CITY OF ALBUQUERQUE

October 12, 2018

**Re: Del Webb @ Mirehaven Units 3 & 4
Grading and Drainage Plan Engineer's Stamp dated: 7/9/2018, Drainage
Report Engineer's Stamp dated 5/10/2018, and Amendment #1 to the
Drainage Report Engineer's Stamp dated: 9/18/2018 (H09D017G)**

CITY OF ALBUQUERQUE DEPARTMENT OF MUNICIPAL DEVELOPMENT	
DEL WEBB @ MIREHAVEN PHASE 3 OVERALL GRADING PLAN			
DESIGN REVIEW COMMITTEE	CITY ENGINEER APPROVAL	MO./DAY/YR.	MO./DAY/YR.
	LAST DESIGN UPDATE		
CITY PROJECT NO.	ZONE MAP NO. H-8/9	SHEET 1	OF 6

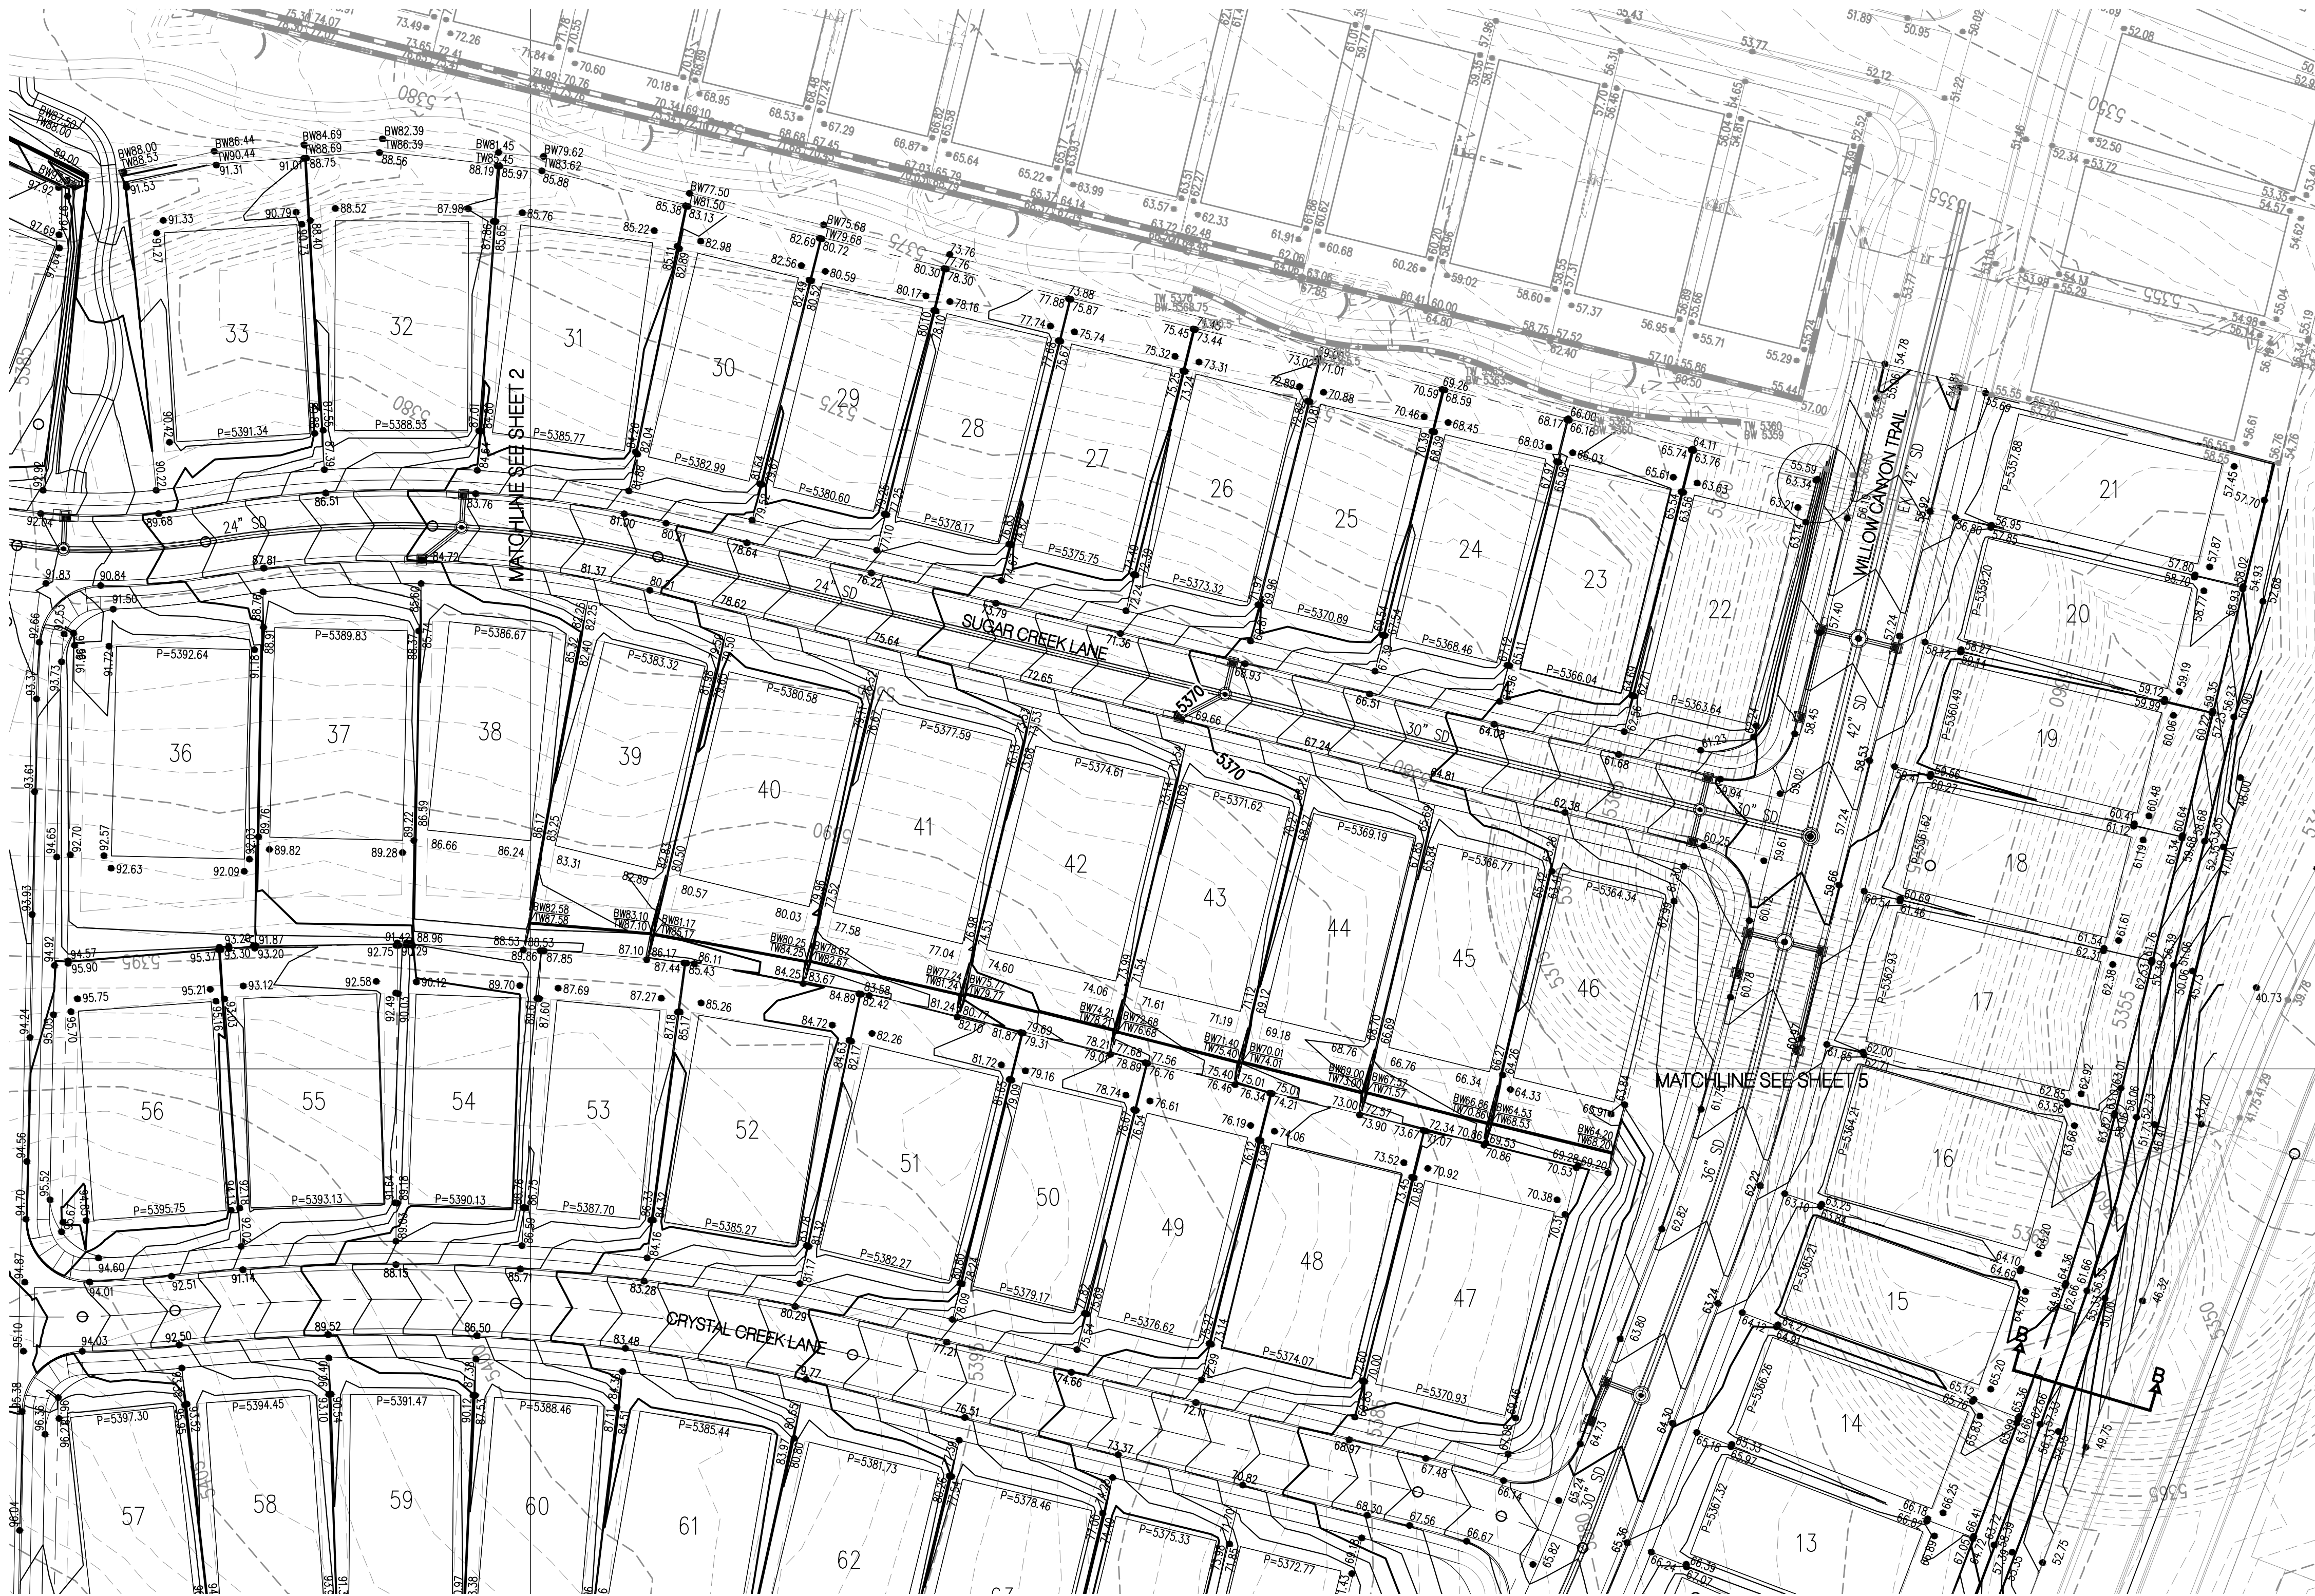
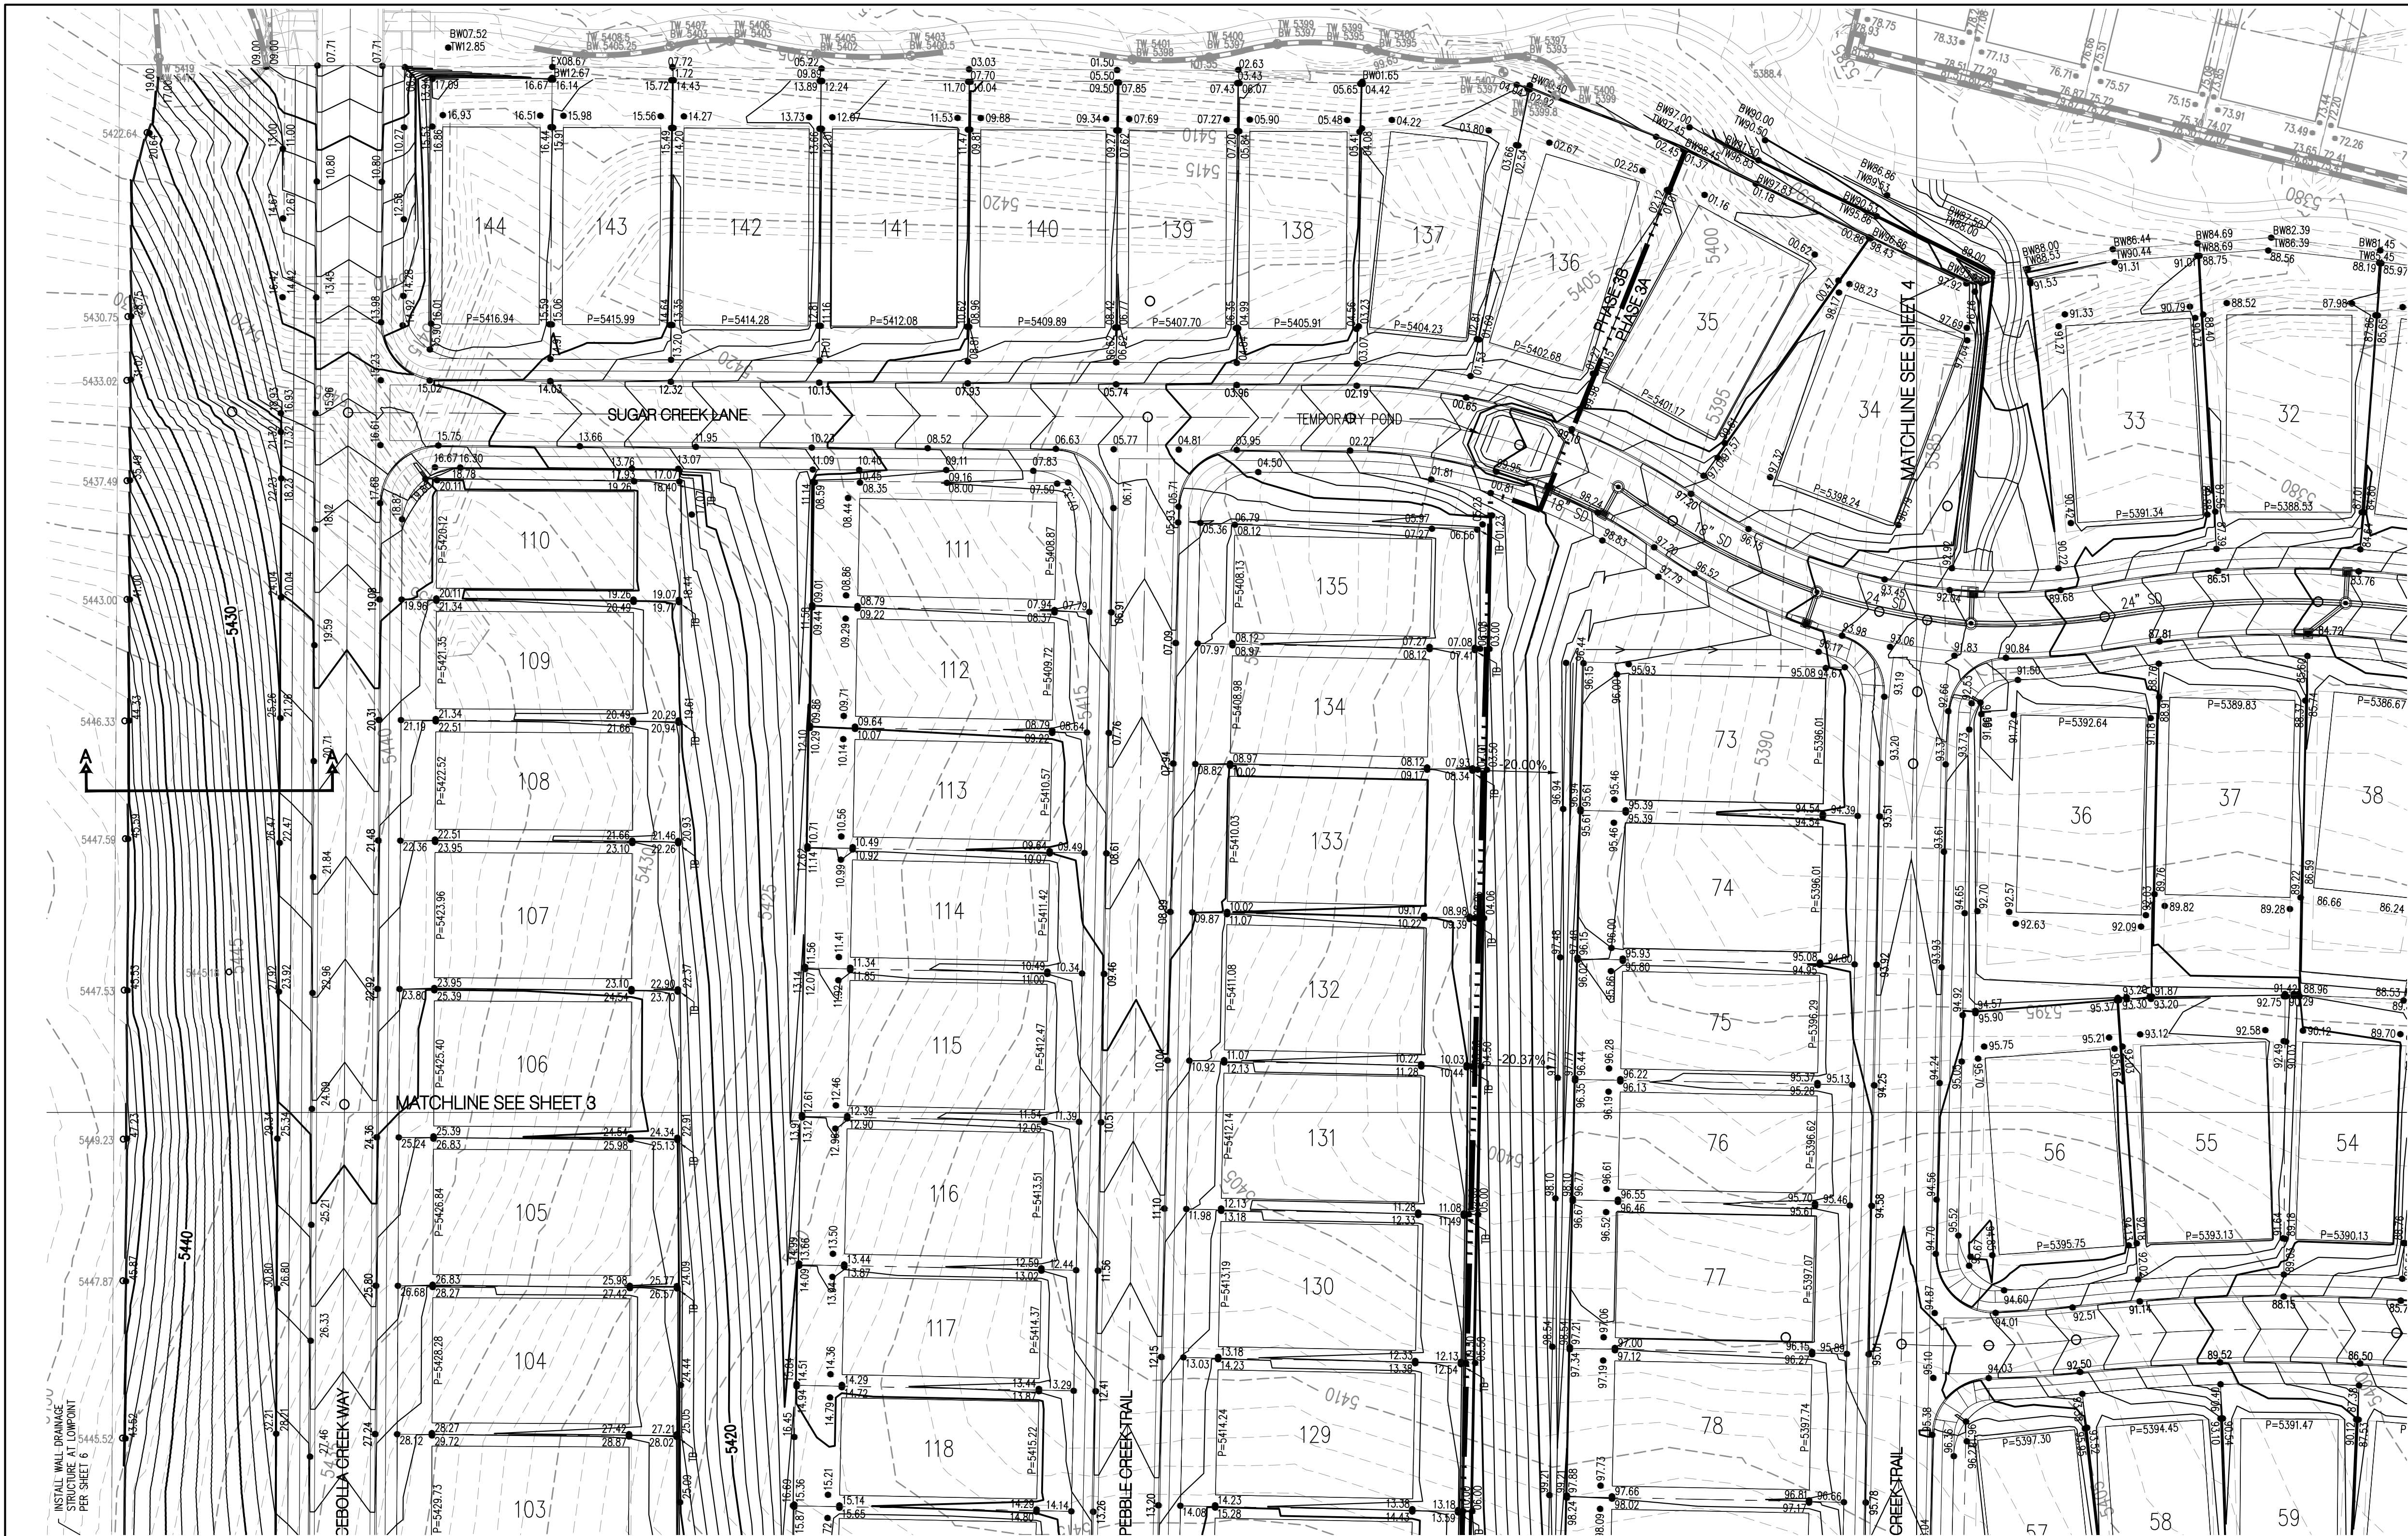
1. The Grading and Drainage plans were only approved for Preliminary Plat and amended Site Plan for Building Permit, so grading has been going on without approval for Grading Permit. The Grading and Drainage plans need to be updated where changes have occurred during Work Order review and the plans resubmitted for Grading Permit.

4. Label the inverts of the pipes, the top elevation of the baffle, the normal pool elevation and pond volume, the Q_{100} , and the 100 year water surface elevation on the grading plan and on the pond detail. The 100 year water surface elevation should be based on either weir depth over the baffle or inlet control on the outlet pipe whichever is higher plus losses between the pond and inlet. The calculations and an explanation of the calculations are required in the amendment. A section showing the length of the weir should be added. Hydraulic calculations must be contained in a bound report with an engineer's stamp and signature on it.

5. The invert of the pipe into the pond should be set at the invert of the pond, or provide a concrete rundown between the end of the pipe and the invert of the pond. Riprap is not sufficient to stabilize the slope when subject to concentrated flow and should be only used in the flat part of the pond bottom. Specify the
